Our Ref: L10002765
19 August 2026

**Arrangements for Handling Heritage Applications Direction 2021 & Planning
(Listed Buildings and Conservation Areas) Regulations 1990**

**The Manor House, 5 East Street
Application No. H02-0670-26**

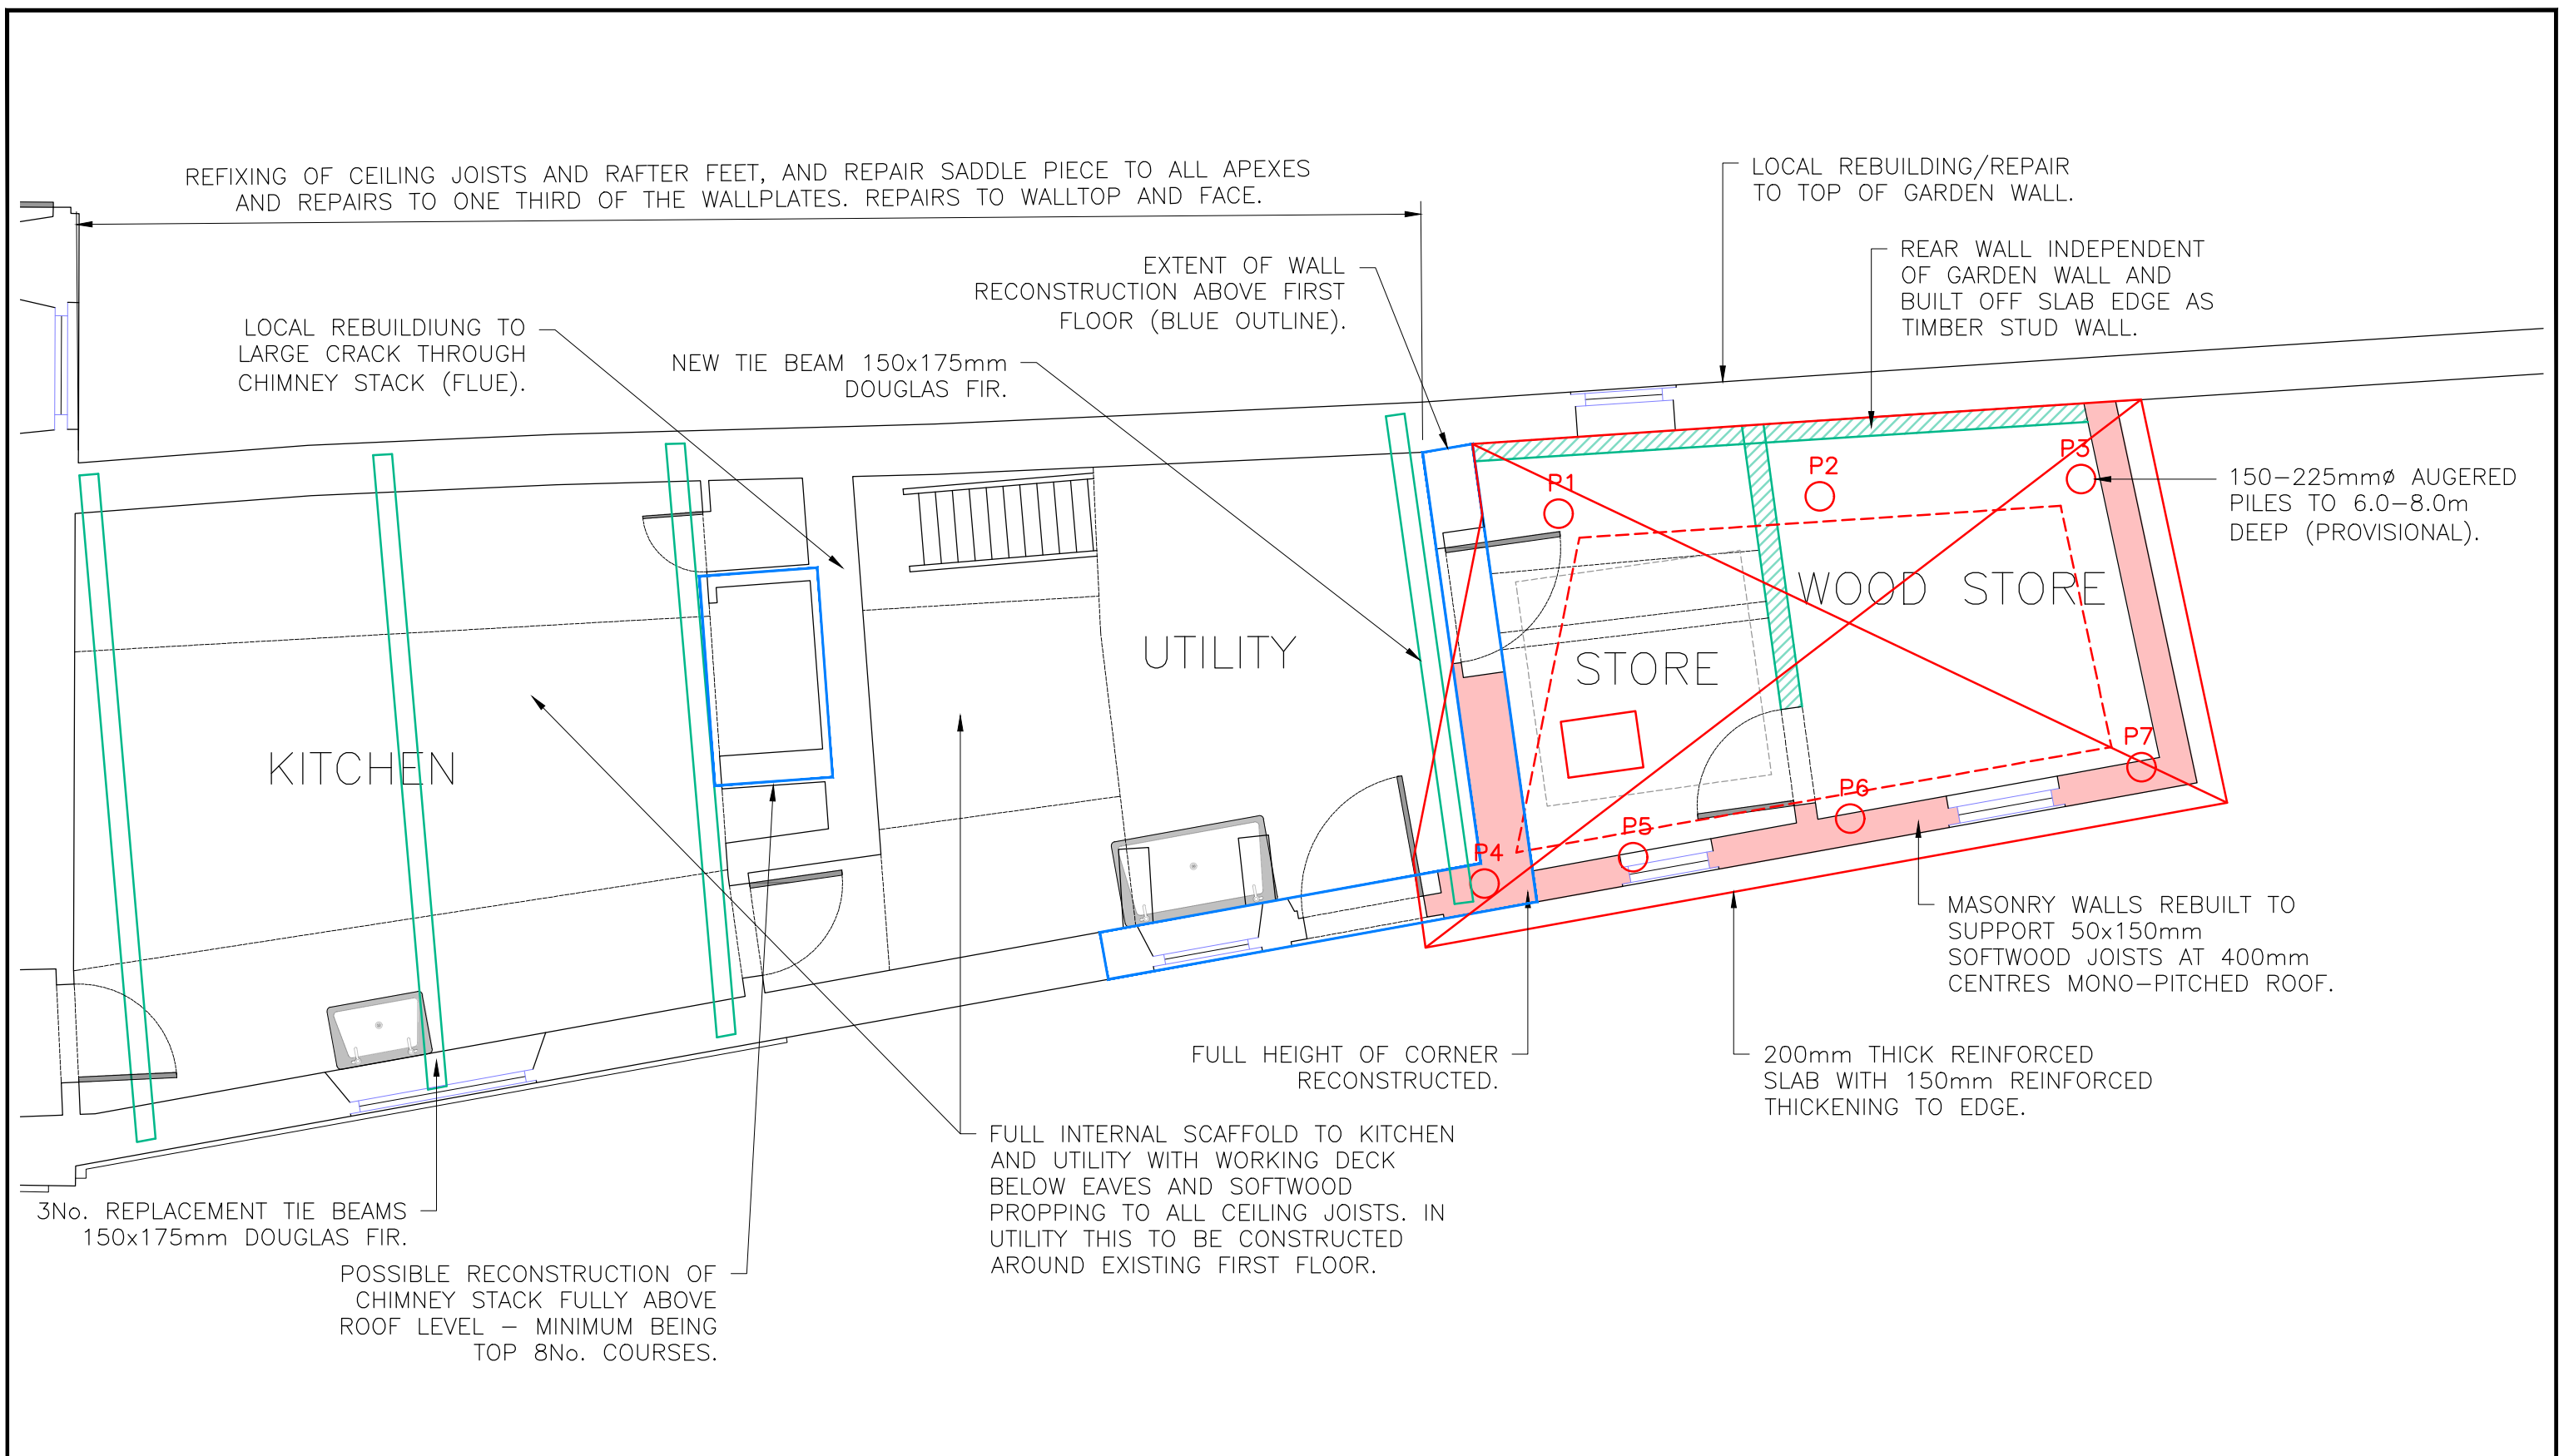
Similarly, structural repairs are proposed to the south gable (of phase E). The extent of works required are currently unknown, pending the demolition of the adjacent single storey outbuilding. If the extent of gable end brickwork proposed to be rebuilt deviates significantly from that indicated on structural drawing ref 22757/R/30 (Rev -) your Conservation Officer should be informed. We also recommend that proposed new brick is specified.

Existing basement and
ground floor plans

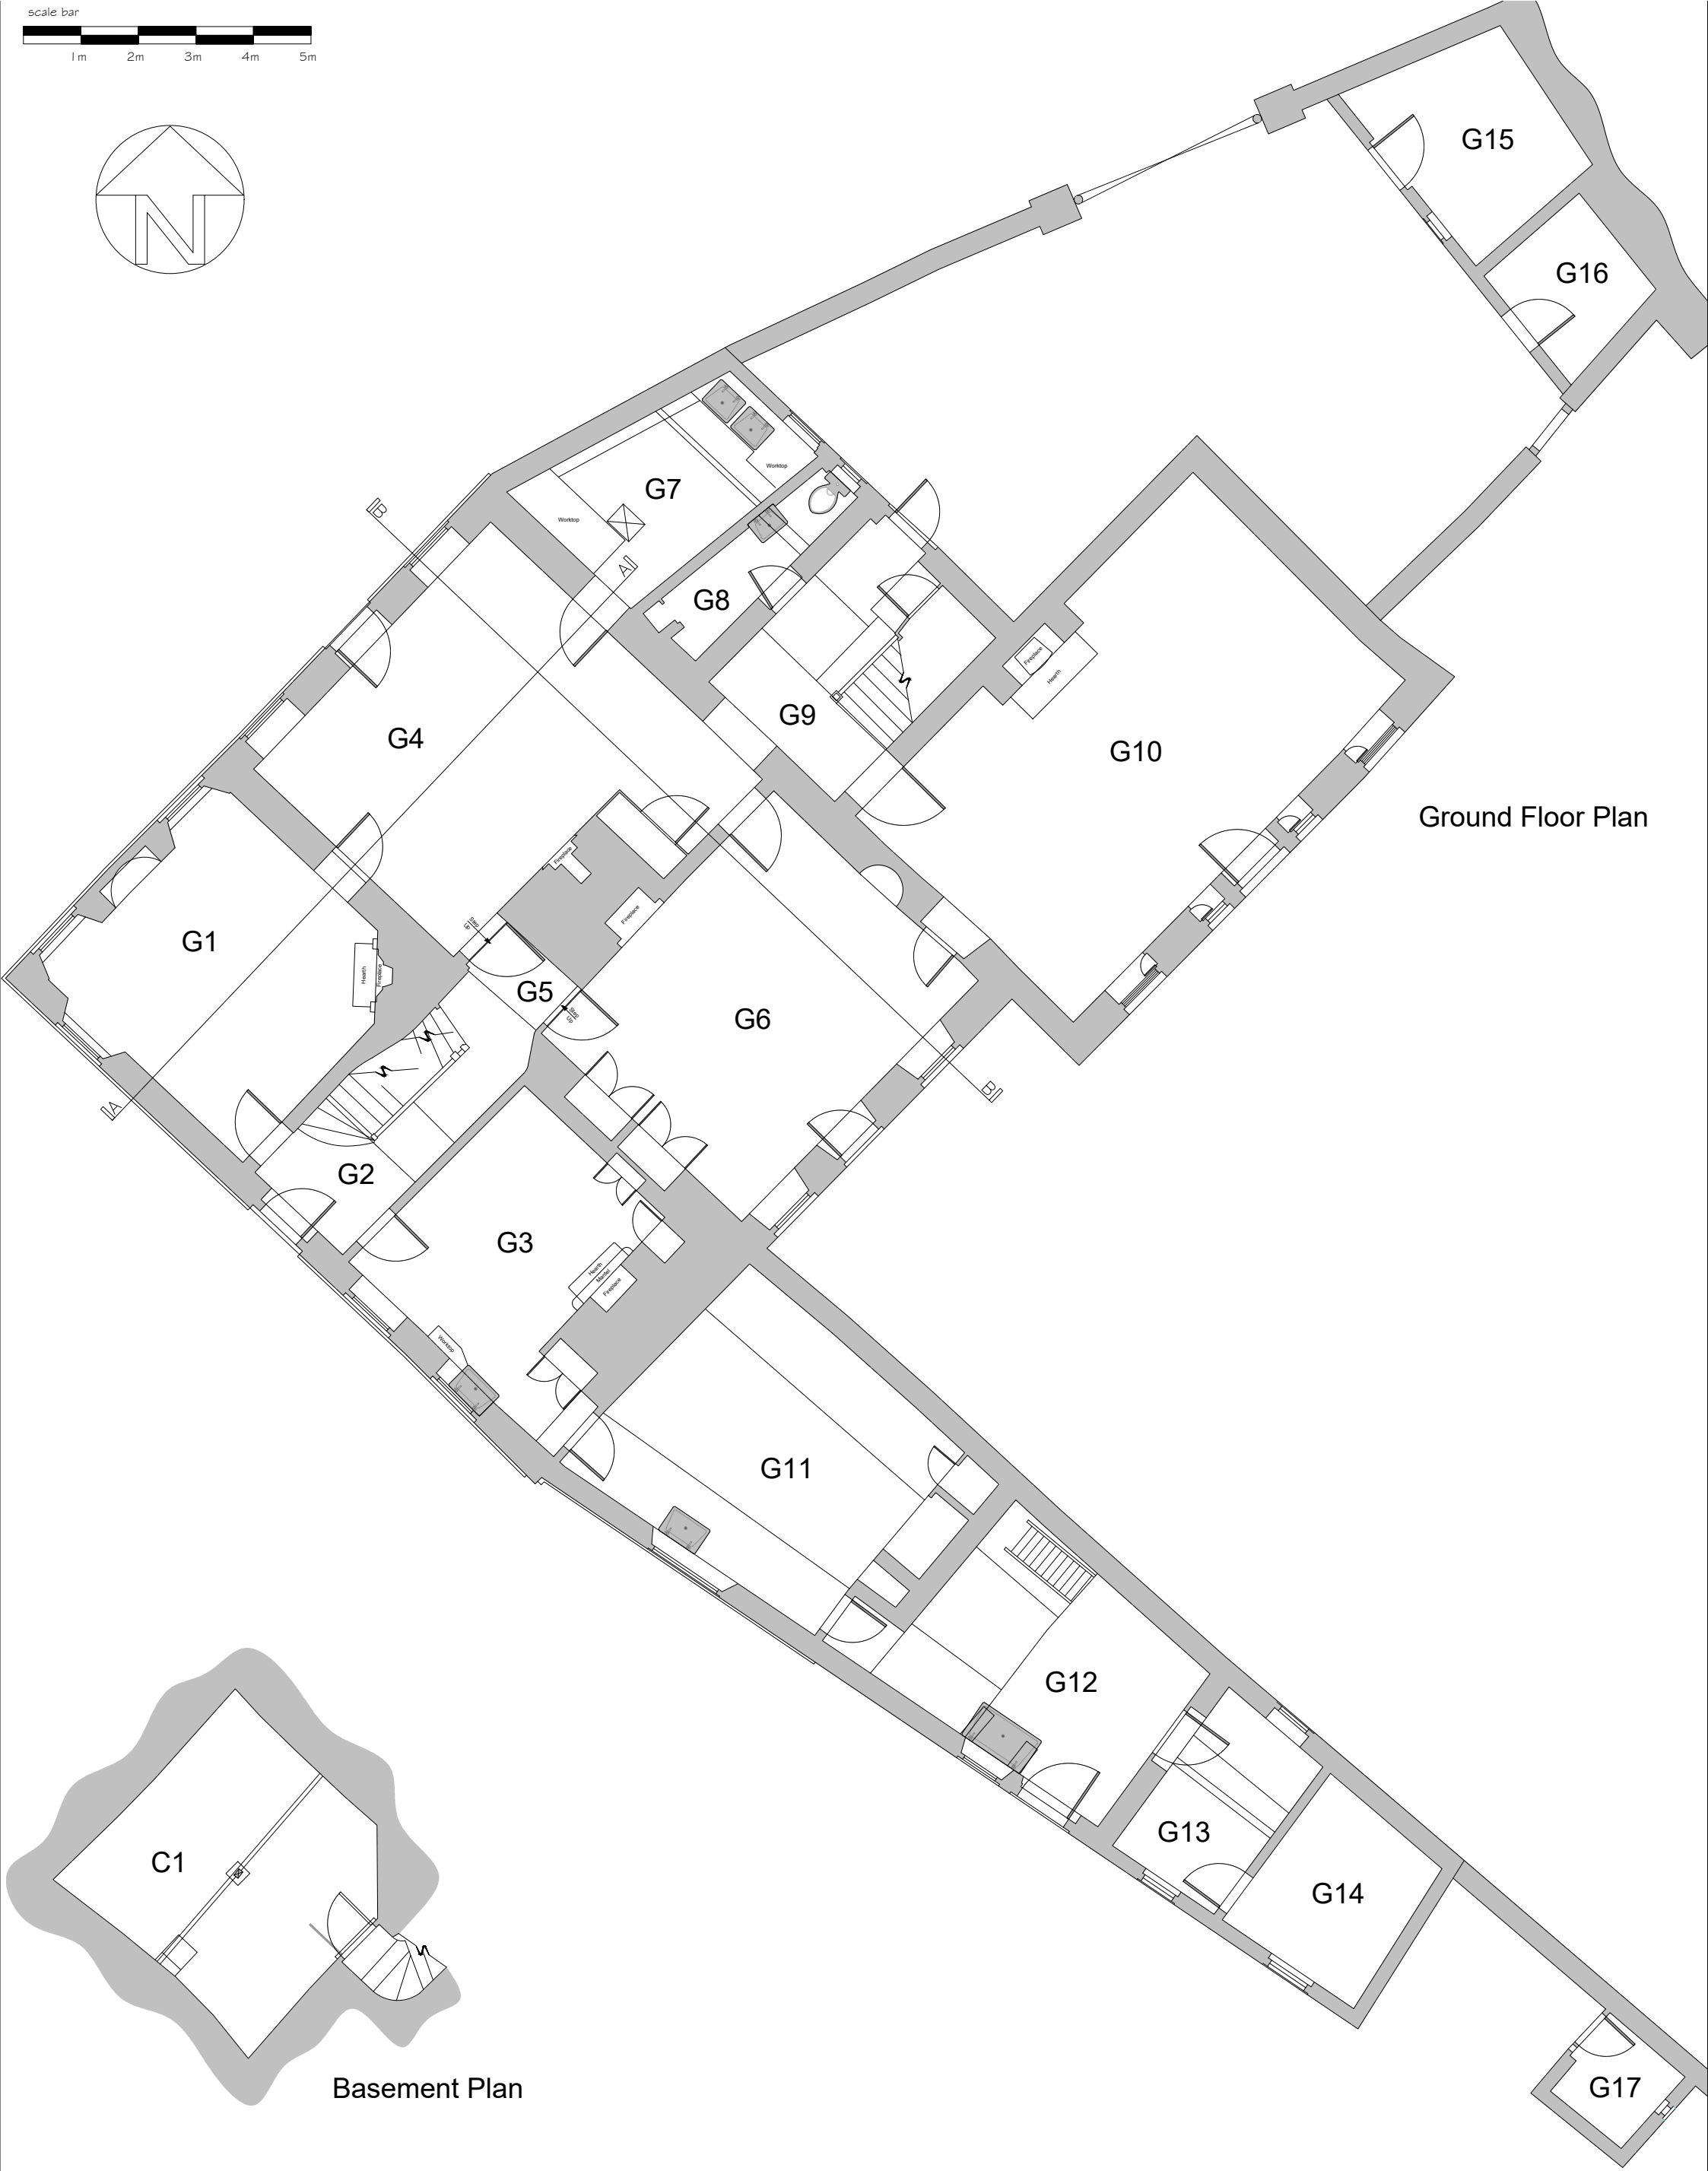
- Specify colour of replacement rainwater goods
- Specify proposed matching bricks for rebuild of garden wall plus proposed mortar mix
- Specify proposed replacement pavement tiles to room G12

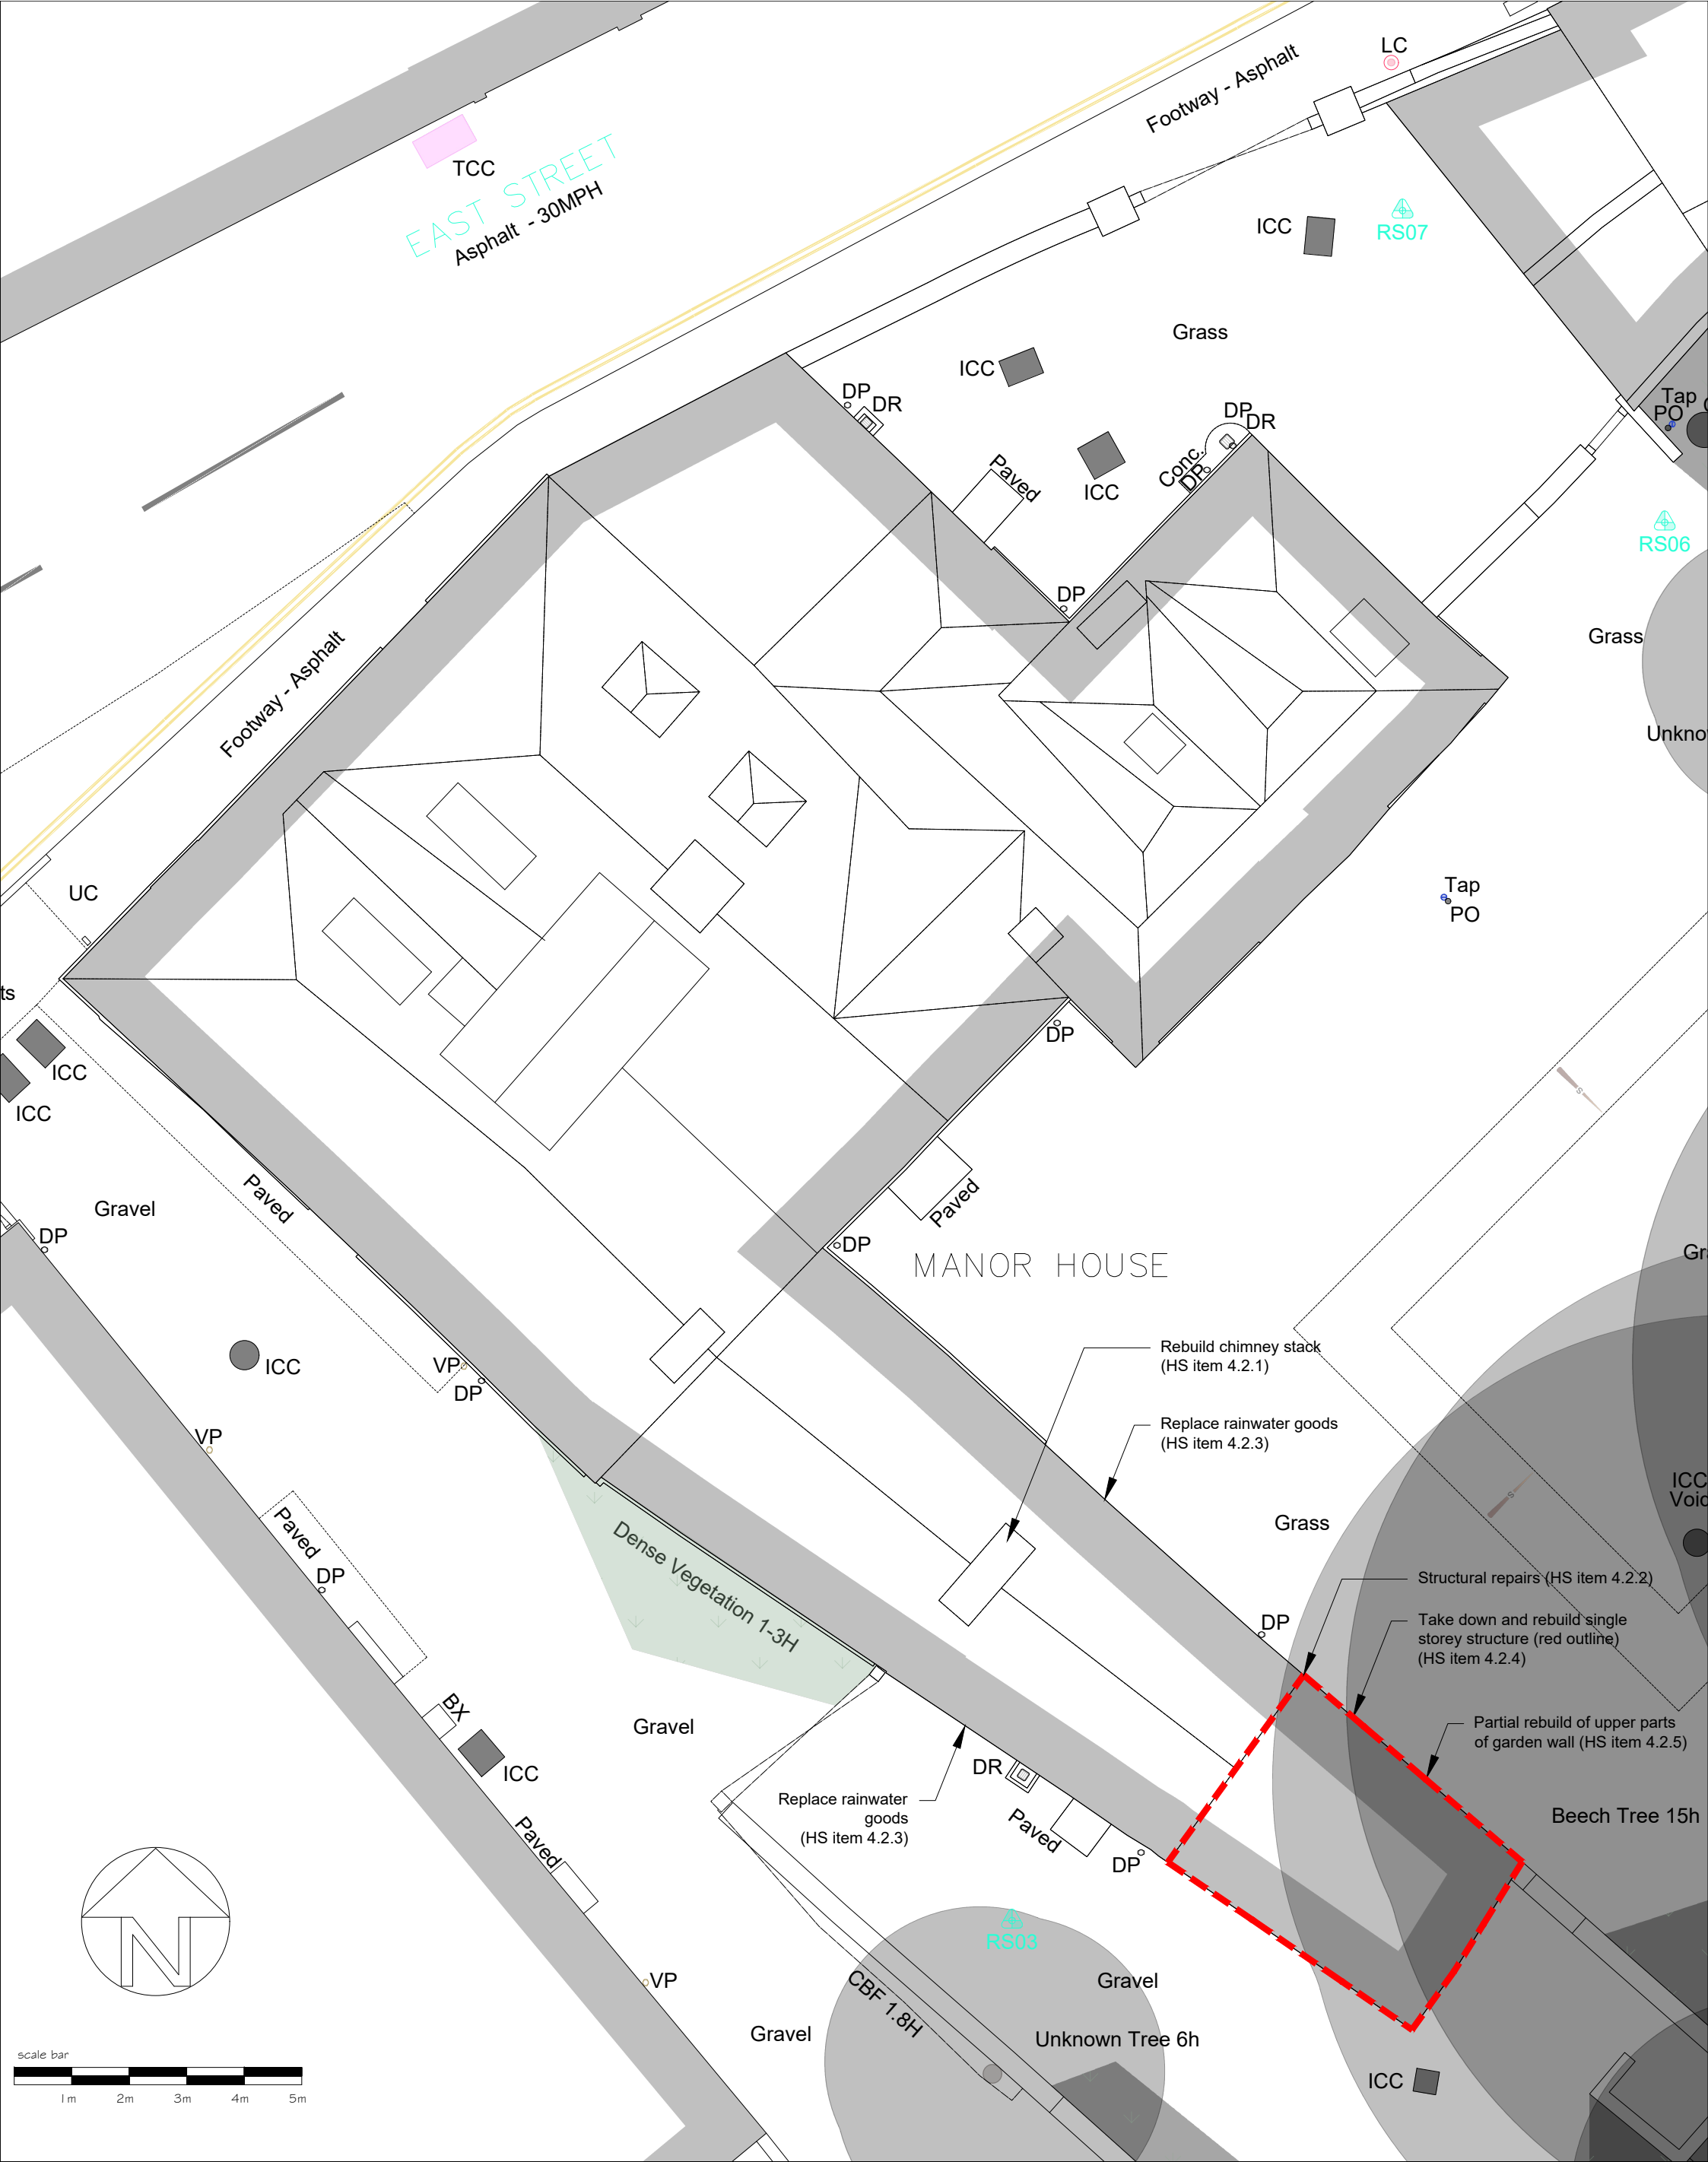
It is proposed to rebuild the chimney stack to the phase E ridge. The application notes that '*The precise specification of works to be undertaken to the chimneystack need to be finalised [...] secured by condition*'. There is currently insufficient detail to describe the extent of the work, so we underline the importance of securing by condition to prevent harm.
